**MORGAN AND MORECAMBE OFFSHORE WINDFARMS TRANSMISSION ASSETS:**

**DEADLINE 5 – COMMENTS ON SUBMISSIONS RECEIVED BY DEADLINE 4.**

### **Comments regarding: FLOOD RISK ASSESSMENT REV.04 [REP4-021] [REP4-023], [REP4-025]**

Figure 1.15: Transmission Assets: landfall, onshore export cable corridor and 400 kV grid connection cable corridor - Watercourses, EA Flood Zones and EA Spatial Flood Defences

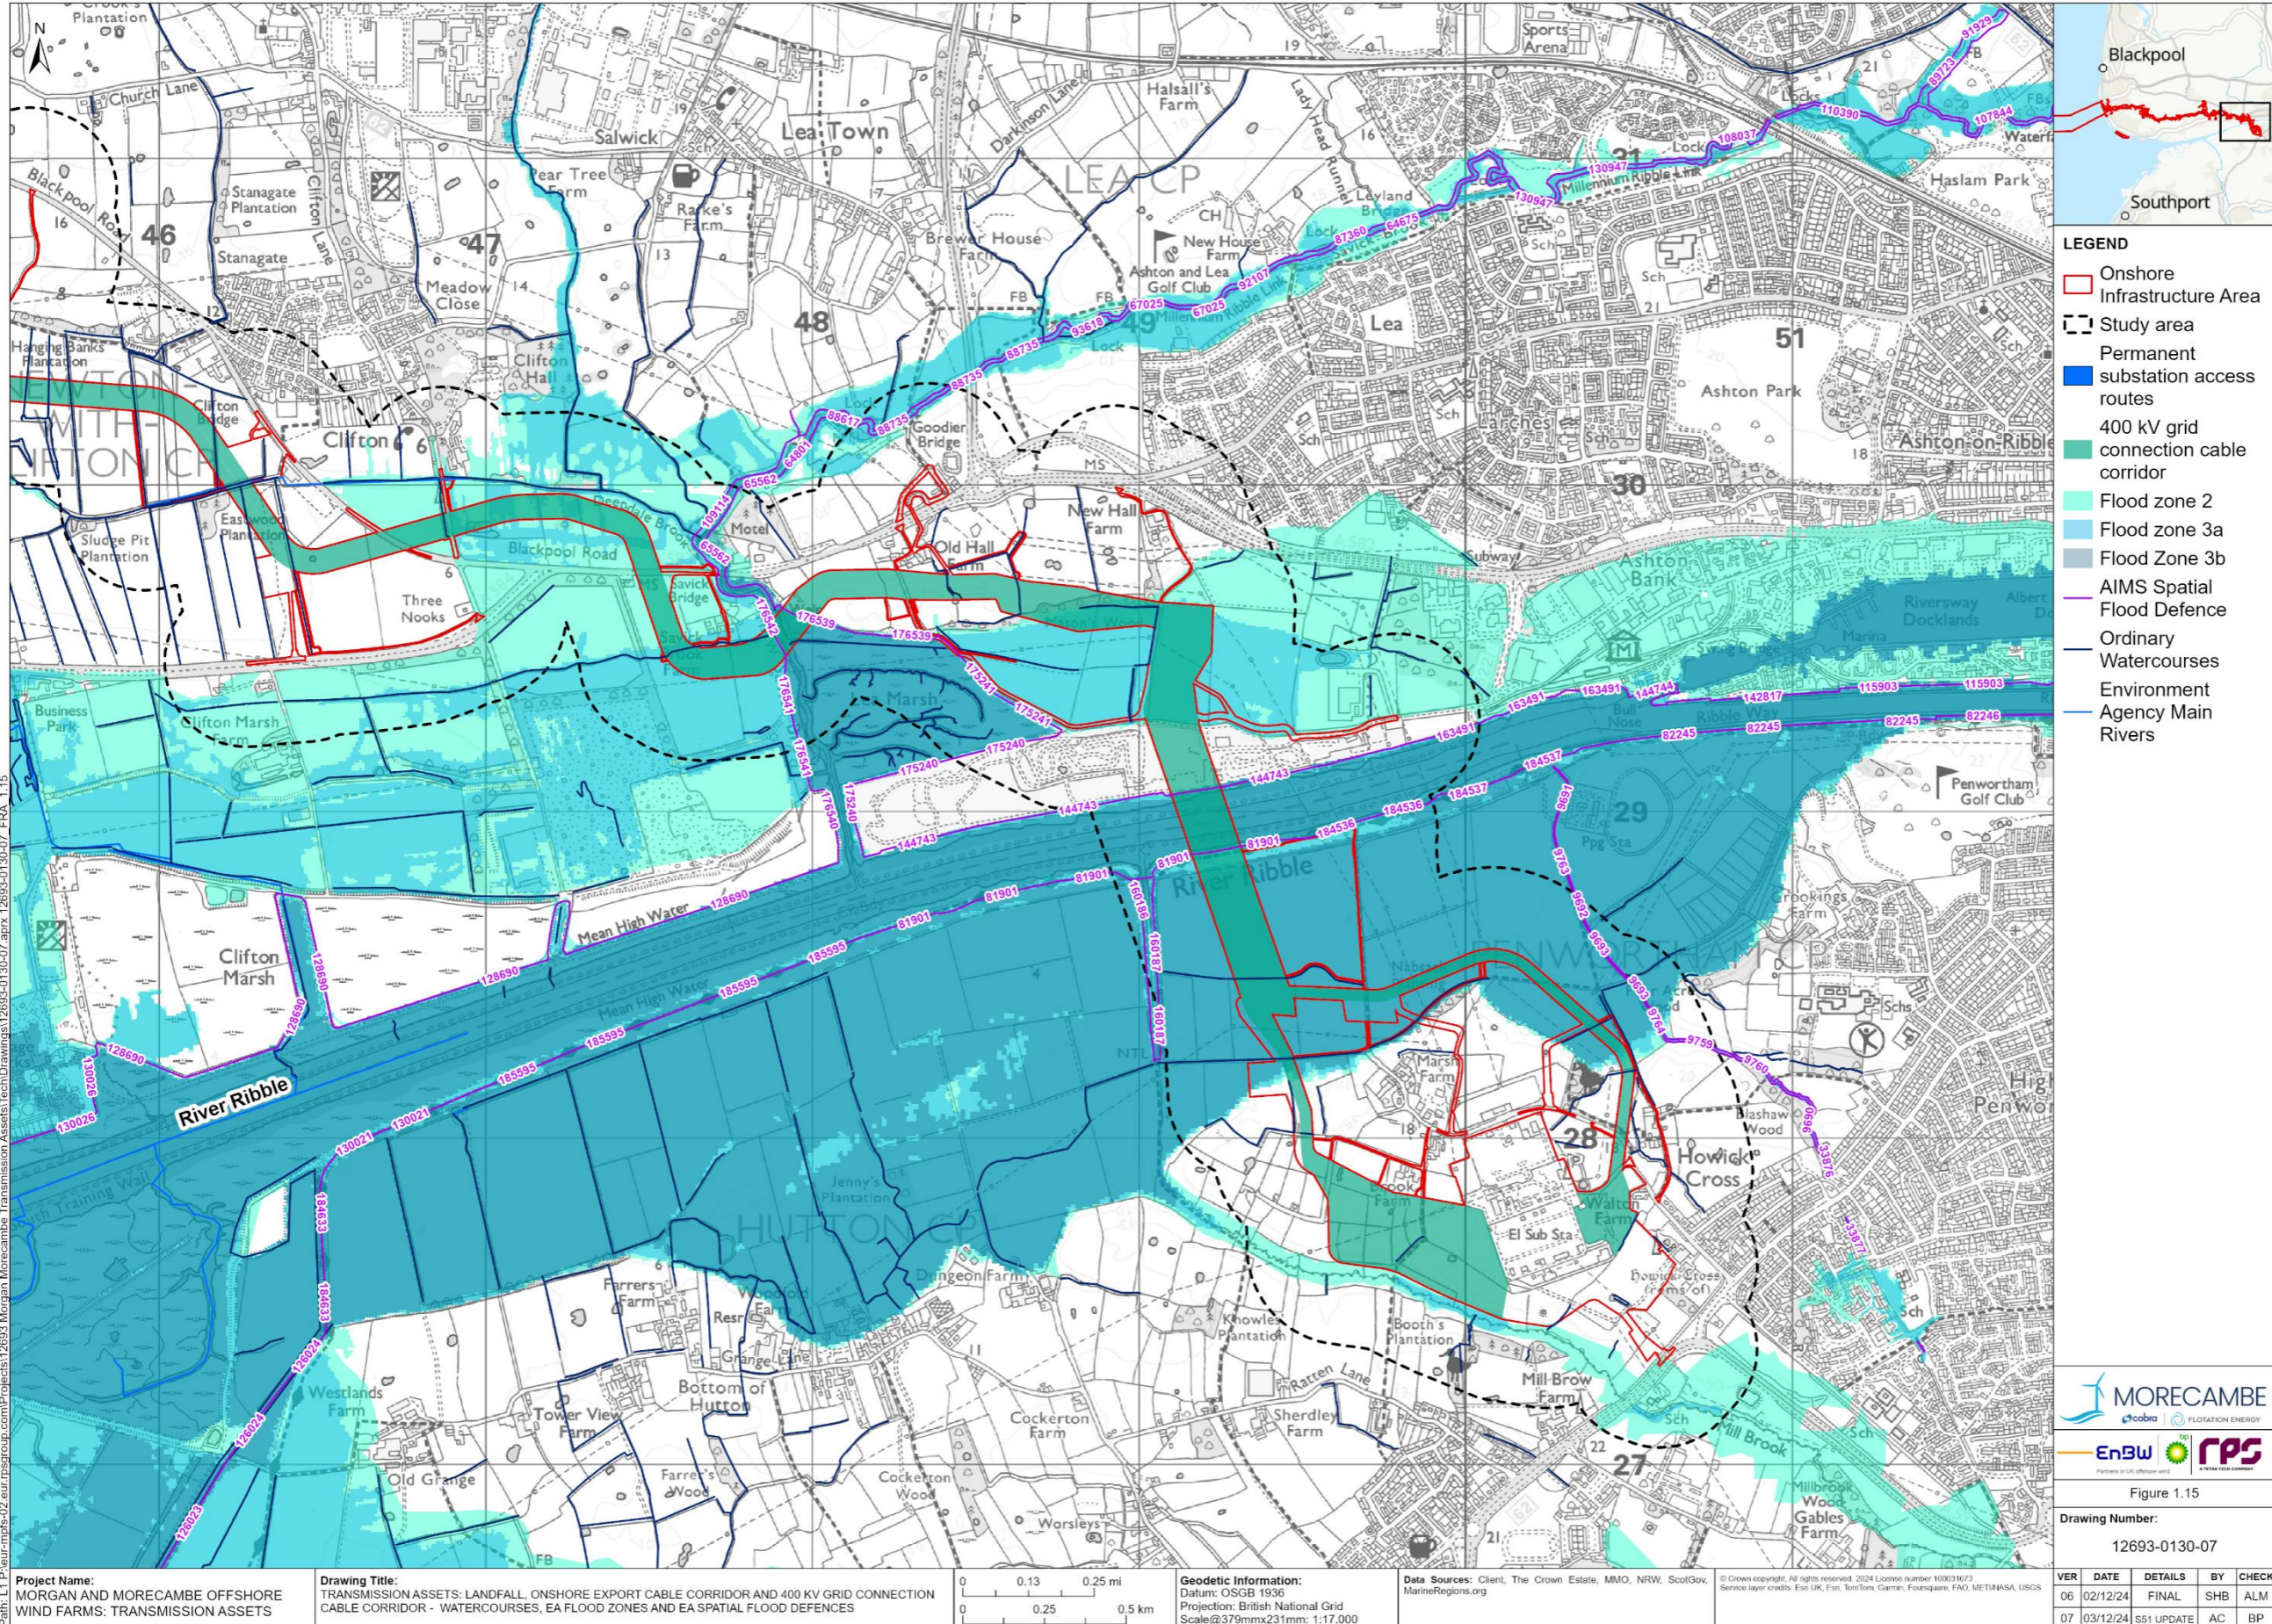
Flood defences 1.6.2.4 Page 131	The Environment has been changed to 'Environmental' Agency Spatial Flood Defences.	No impact, but no reason why it should have been changed.	Change 'Environmental' back to Environment Agency.
Page 162	The drawing does not have a figure title.	Seem like an oversight to not have a figure title.	Include drawing title.
Pages 163-166	Changing in titles and figure numbers appears to have resulted in a discrepancy between the new figure label in the report and the figure reference in the original title box of the drawing.	This makes references somewhat problematic and confusing.	Clerical error requiring correction

Figure 1.16a: Defended 1% AEP fluvial event plus 20% climate change uplift

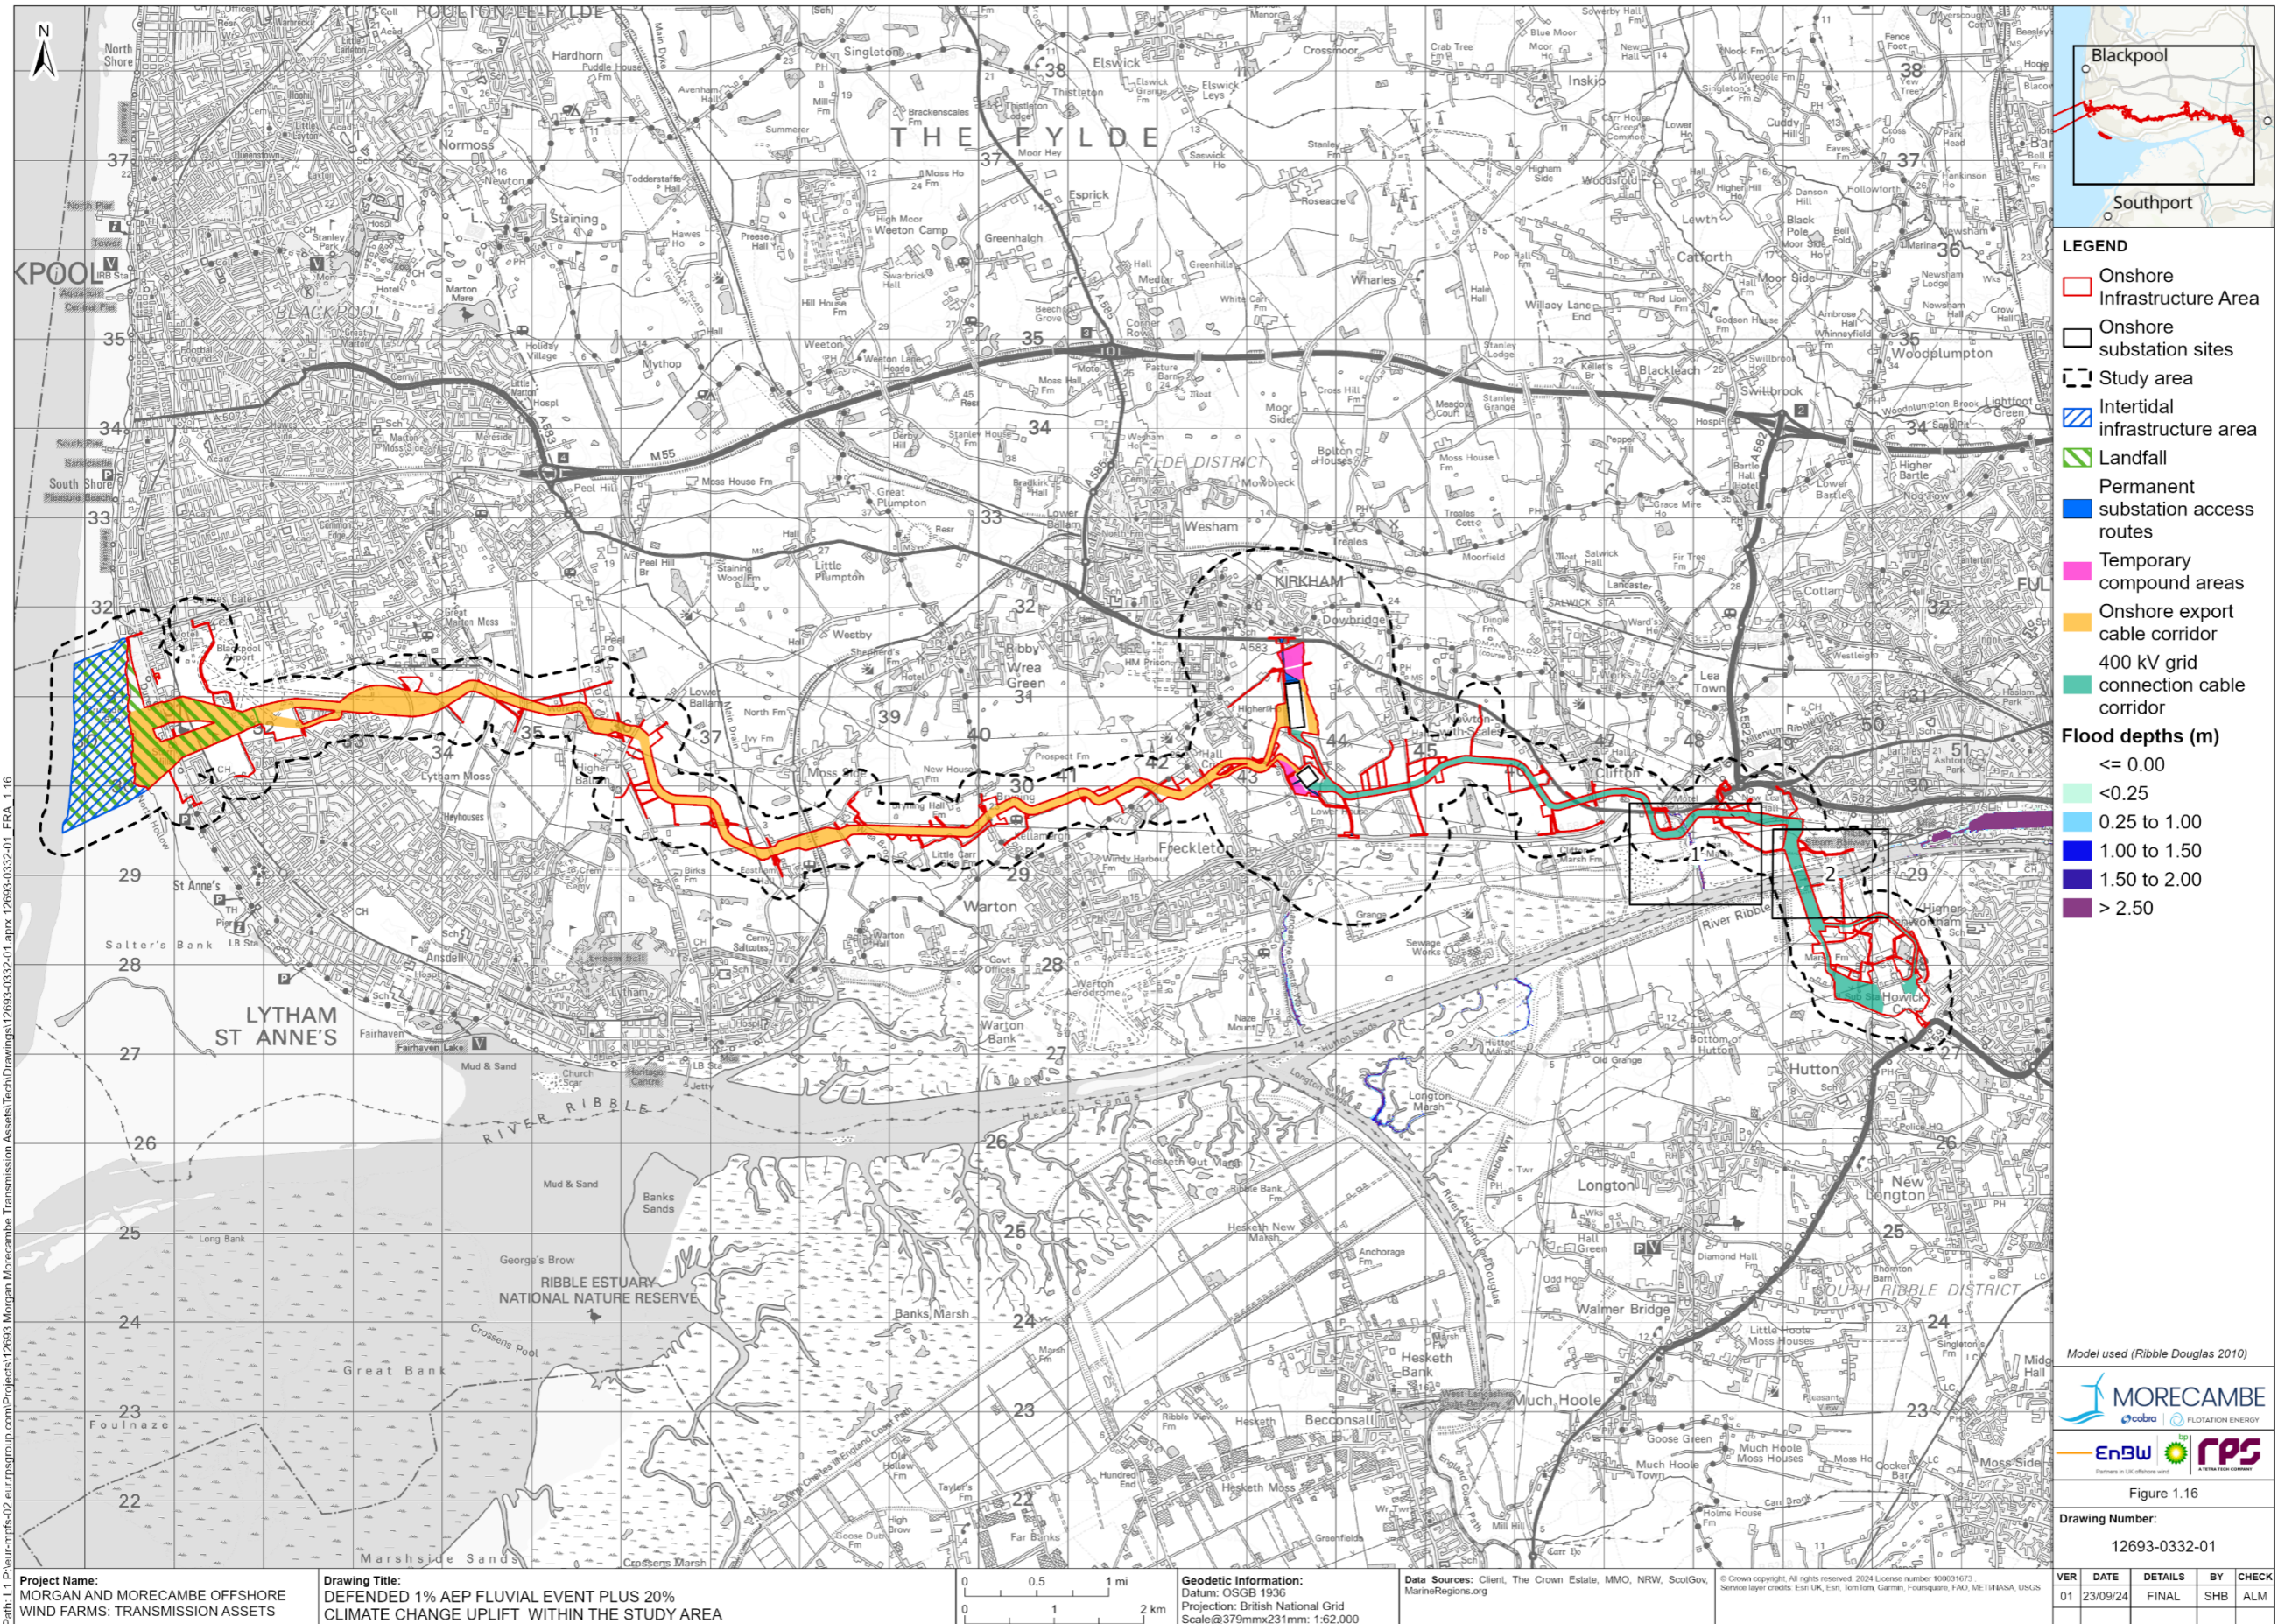
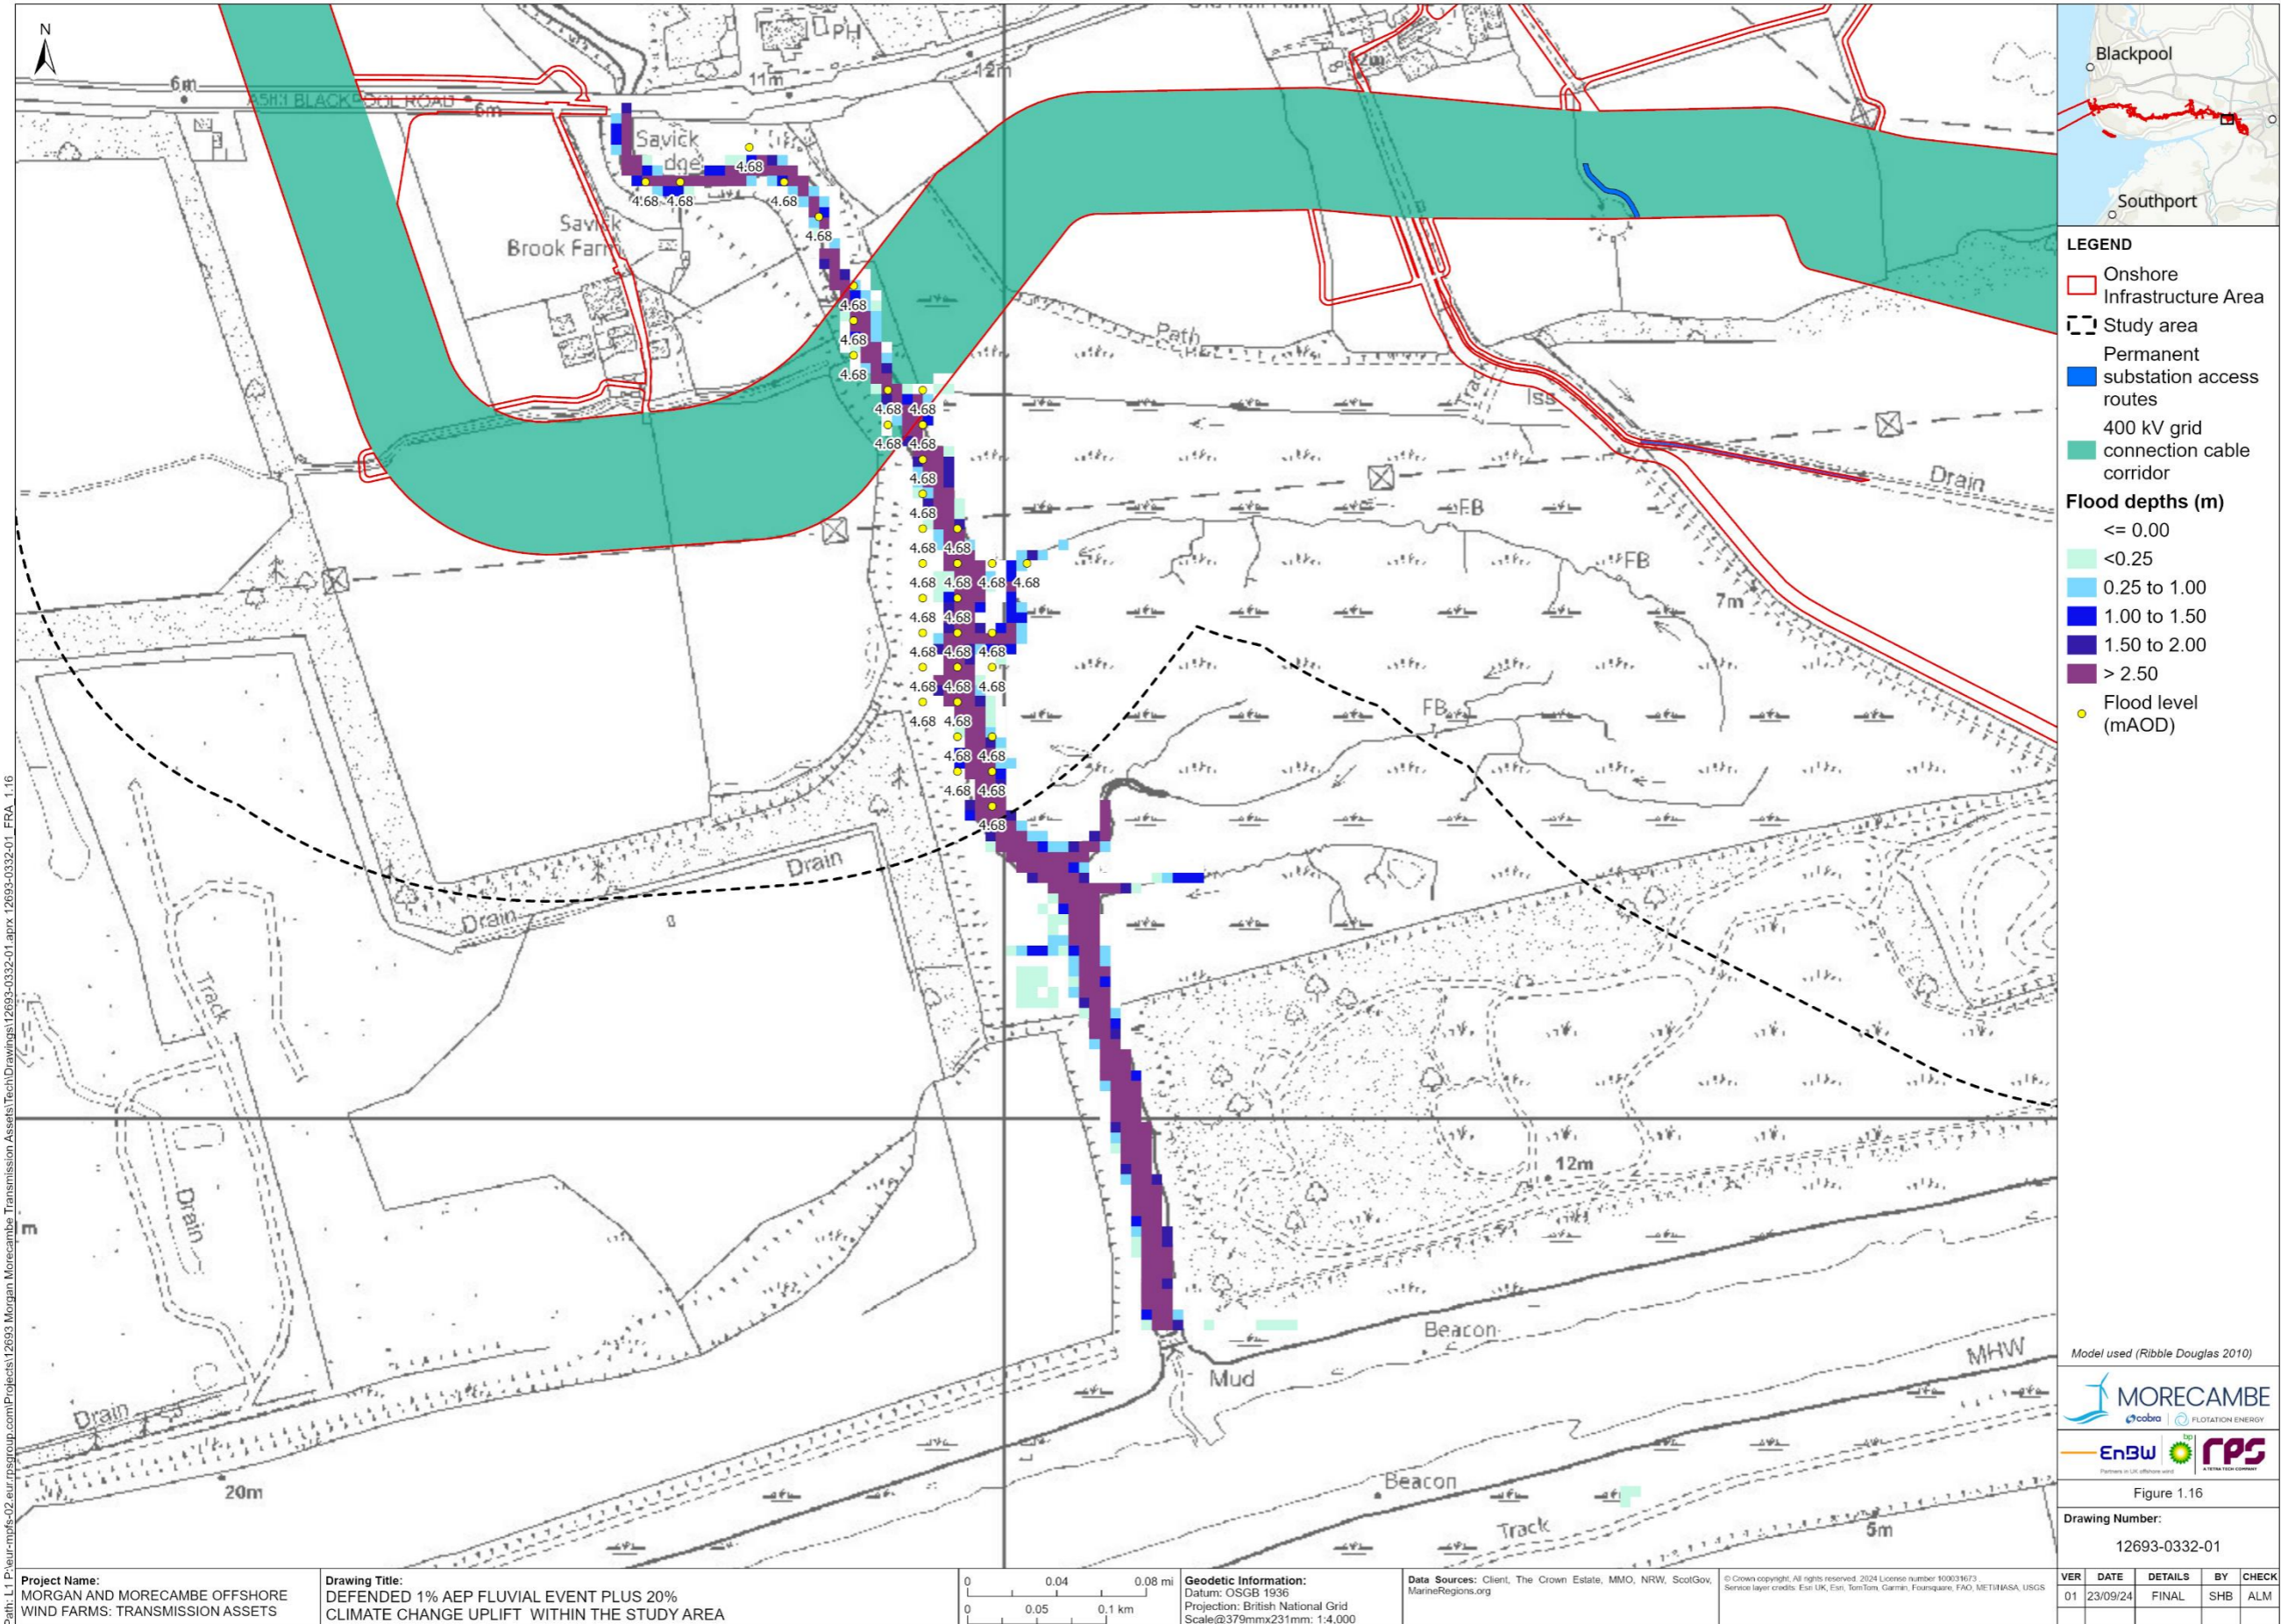
<p>Like previous comments.</p> <p>Changing in titles and figure numbers appears to have resulted in a discrepancy between the new figure label in the report and the figure reference in the original title box of the drawing.</p> <p>e.g. Figure 1.23: Undefined 1% AEP fluvial event plus 20% climate change uplift on Page 199 is figure 1.17 in the drawing title box.</p>	This makes referencing somewhat problematic and confusing.	Clerical error requiring correction
--	---	--	-------------------------------------
